Mona PEIR Submission

Stena Line Response

1.1 This document constitutes Stena Line's response to the Planning Environmental Information Reports ("**PEIRs**") for the Mona Offshore Wind Project (the "**Project**").

Passage North of the Isle of Man

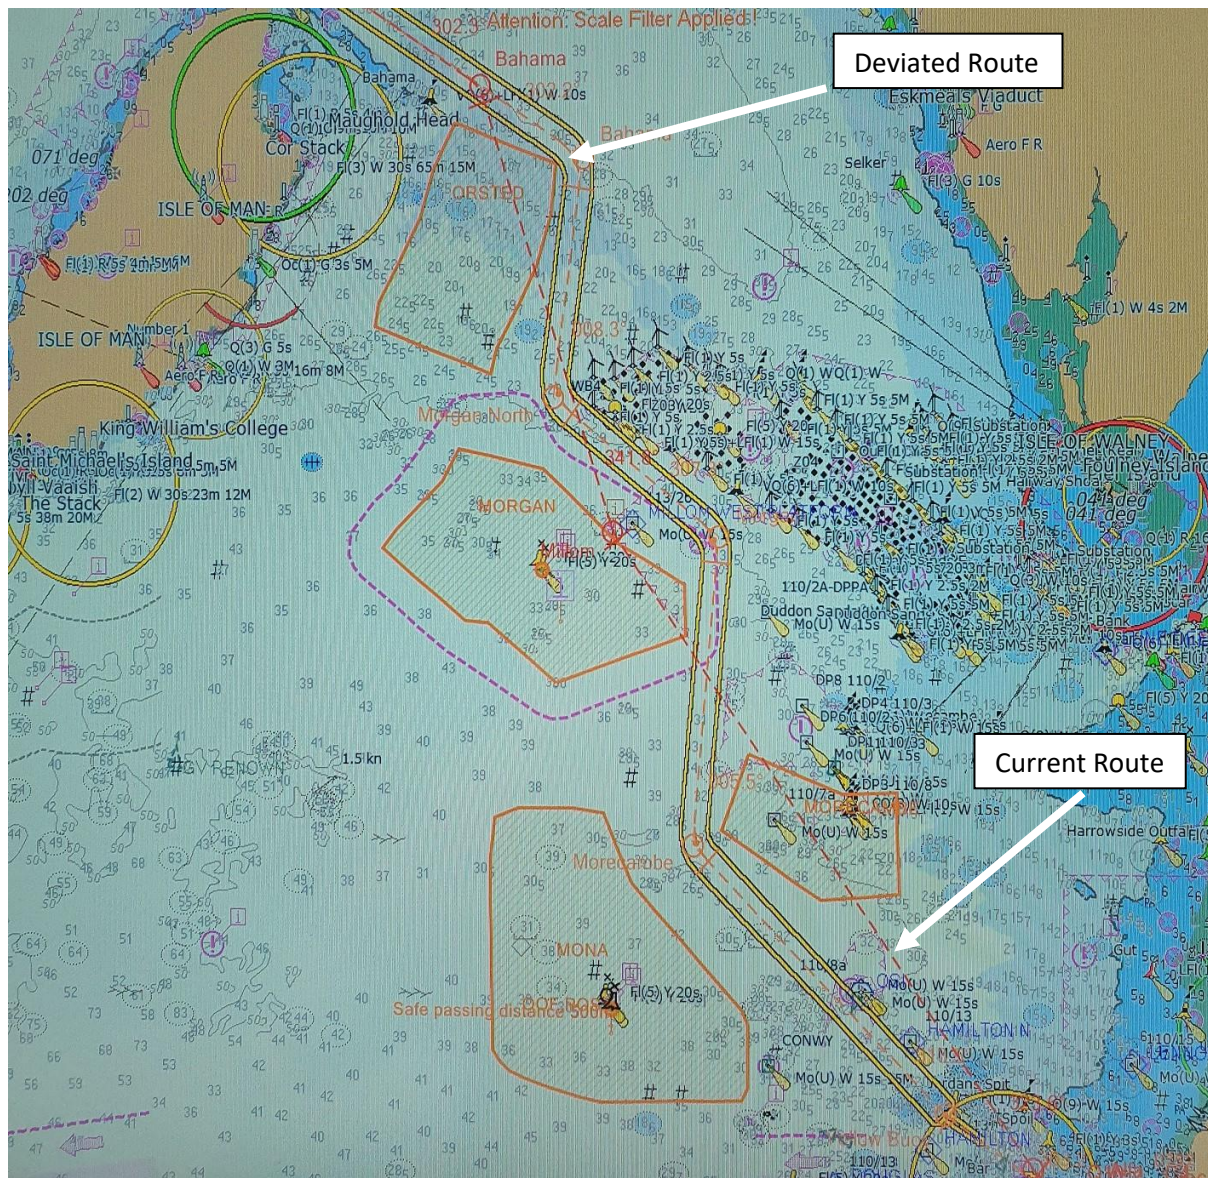
Stena Line's Liverpool to Belfast route is significantly affected by the proposed footprint of the Wind Farms. Stena Line has throughout the consultation period highlighted and requested proper assessment of the impacts of the Wind Farms on ferry routes and in particular the need for a cumulative assessment. Stena Line's primary concern is that of safety and how its' affected vessels will be able to navigate the affected areas safely, especially in adverse weather conditions.

- (b) Considering Figure 12.5 of the Mona PEIR Chapter 12, it is clear Stena Line's routes are significantly affected by the Mona Array Area, in particular due to the routes required during adverse weather conditions. The PEIR estimates the deviation to be 2.6nm/7.4 minutes for the Liverpool-Belfast route per vessel per trip (See Mona PEIR, Chapter 12, section 12.8.3.5.). The deviation is significant for Stena Line's operations which rely on just in time arrival. Just as an example, an additional 2.6nm crossing distance for three vessels twice daily over the 35-year lifespan of the Project is almost 200,000nm in total (before any further deviation created by the Orsted project is taken into account). At current fuel prices, this additional mileage over the lifespan equates to US\$500,000 per annum, or a total of US\$17,300,000. On any view, this is a staggering addition to Stena Line's operating costs.
